Subject: RE: Planning Consultation on: P/88/22/DOC

Application No: P/88/22/DOC
Registered: 24th May 2022
Site Address: Land North of Sefter Road & 80 Rose Green Road Pagham
Description of Works: Approval of details reserved by condition imposed under P/134/16/OUT relating to conditions 10-surface water drainage, 12-maintenance and management of surface water drainage system, 14-foul drainage system, 16-external lighting, 17-Construction Management Plan, 22-setting out when roads, footpaths, cycleways and emergency routes are to be constructed, 26-street lighting and 28 (part)-energy conservation and renewable energy.

North of Sefter Road, Pagham – P/88/22/DOC Comments Tracker				Initial Issue Date: 12-10-2022 Issue Date: - Revision 1.0	
	ADC Drainage Comments 11-10-22	Applicants Response	ADC Drainage Comments 18-11-22	Applicants Response	ADC Drainage Comments 25-01-23
I hereby confirm the surface water drainage design and maintenance manual is satisfactory and recommend 'part' discharge of conditions 10 & 12.					
	Initial/Planning:

Proposed Diversion  
of Existing Ditch  
Section Q-Q  
Scale 1:20

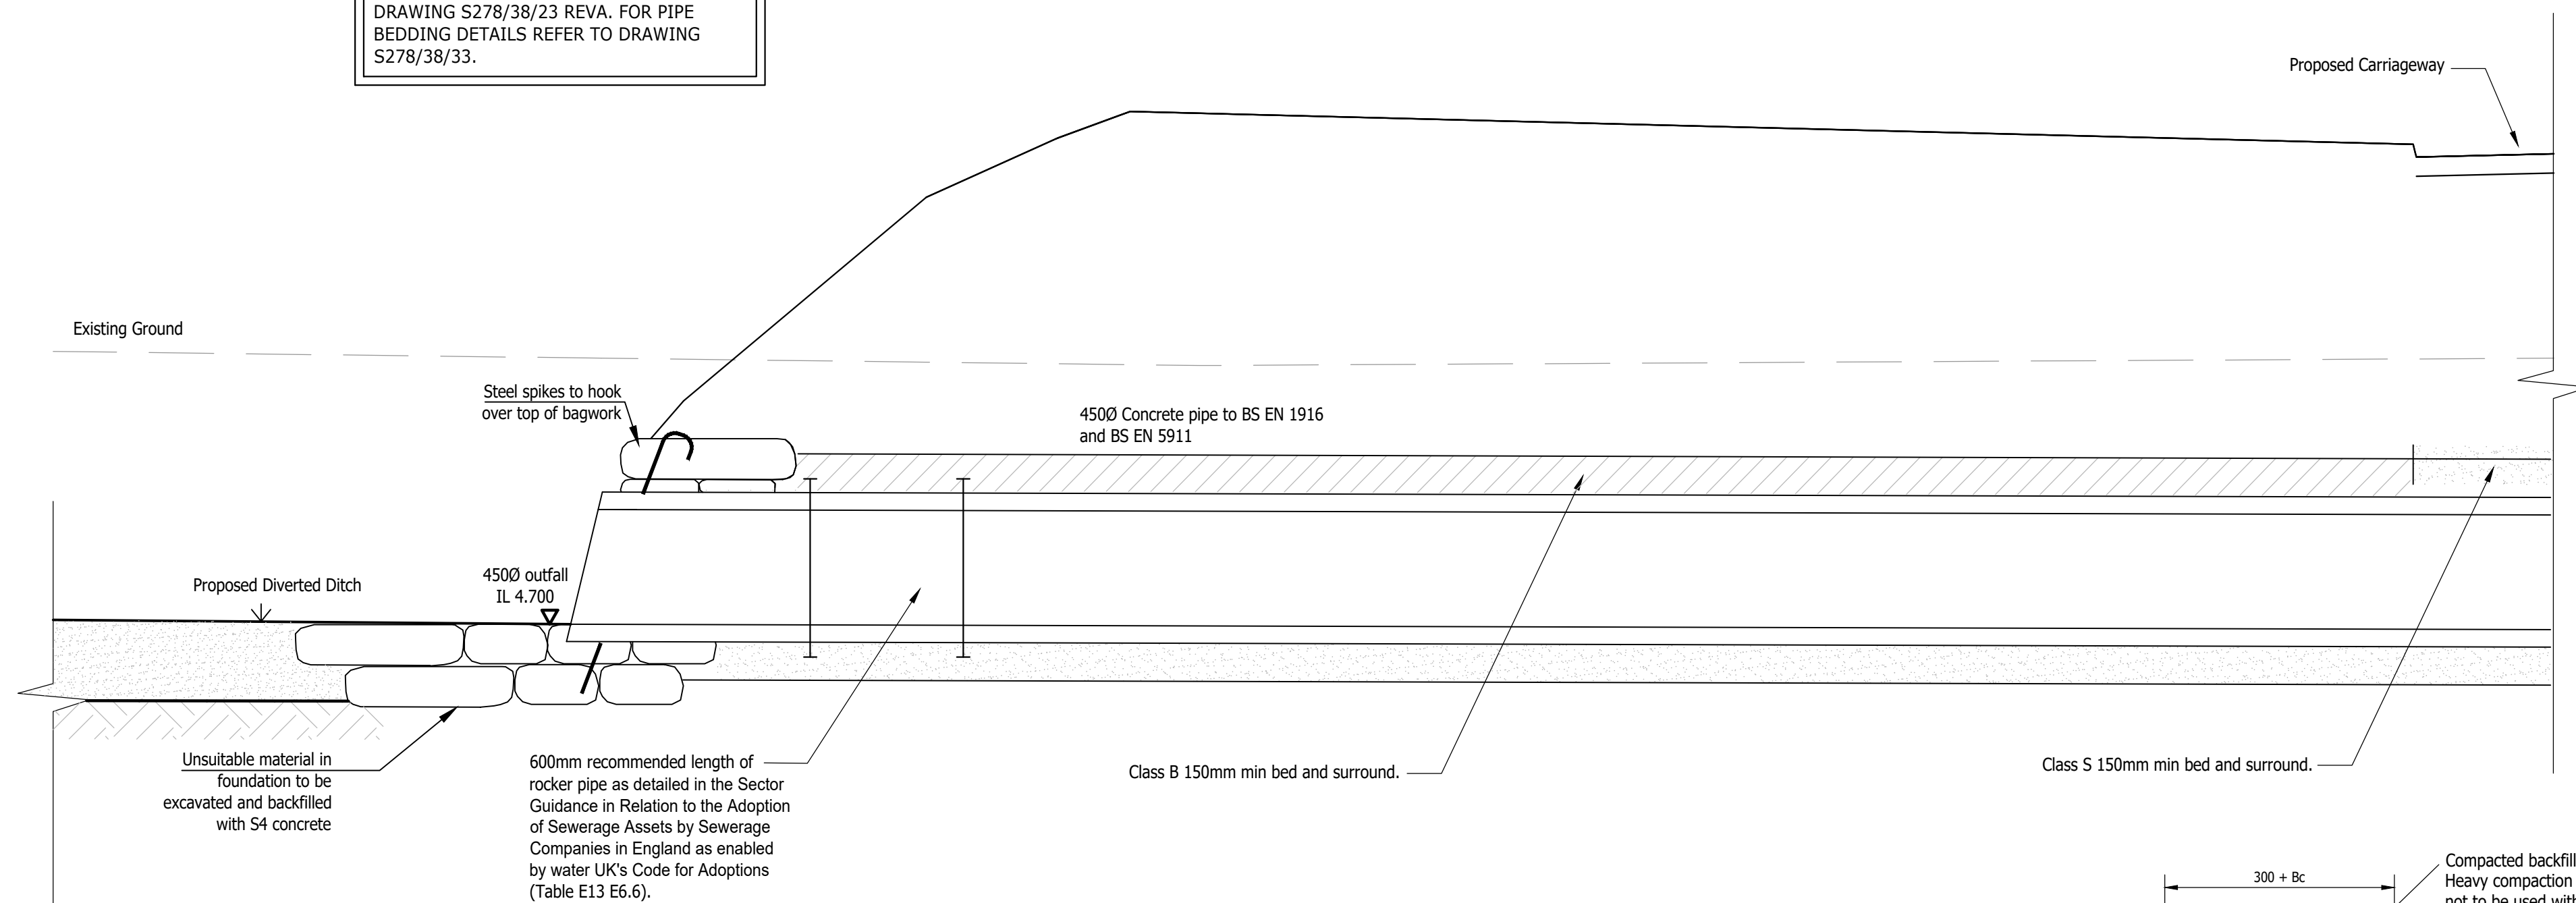
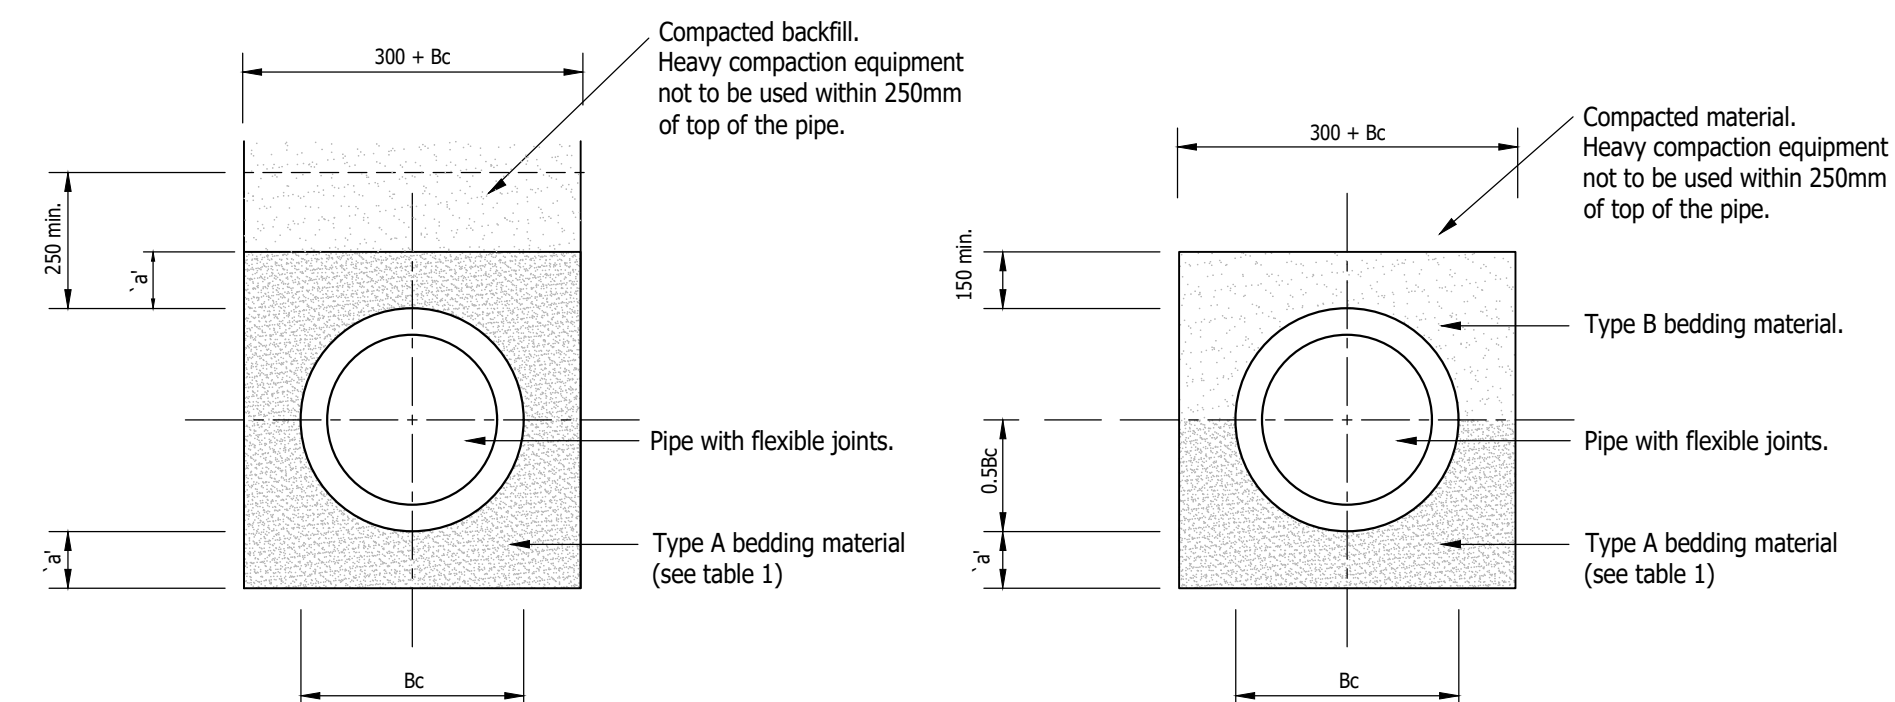
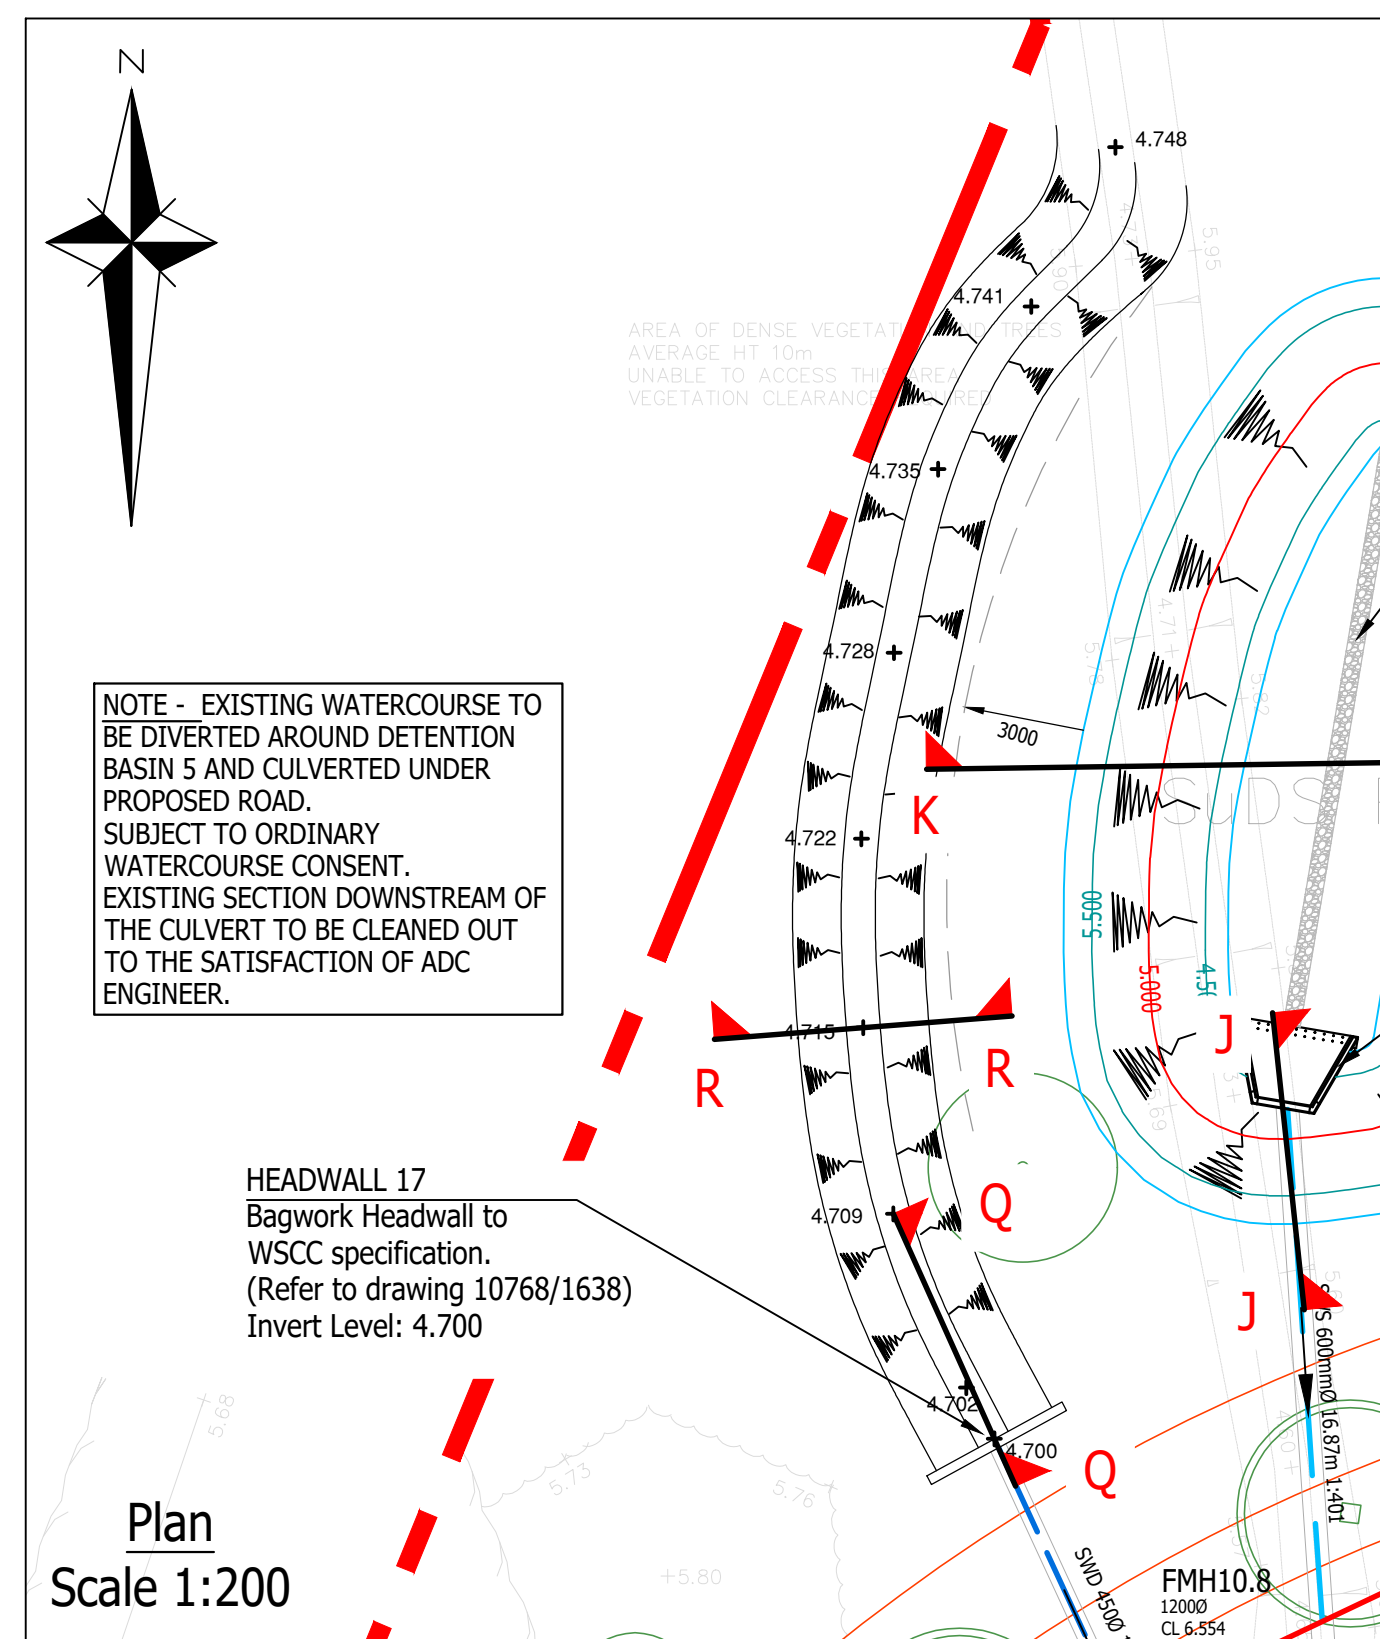
10.	With reference to drawing 1602/P6 the buffer in between the diverted watercourse and SW basin 5 does not comply with the minimum 3.0m.	Proposed diversion and pond orientation adjusted to comply with 3m requirement.	Agreed and closed.	-
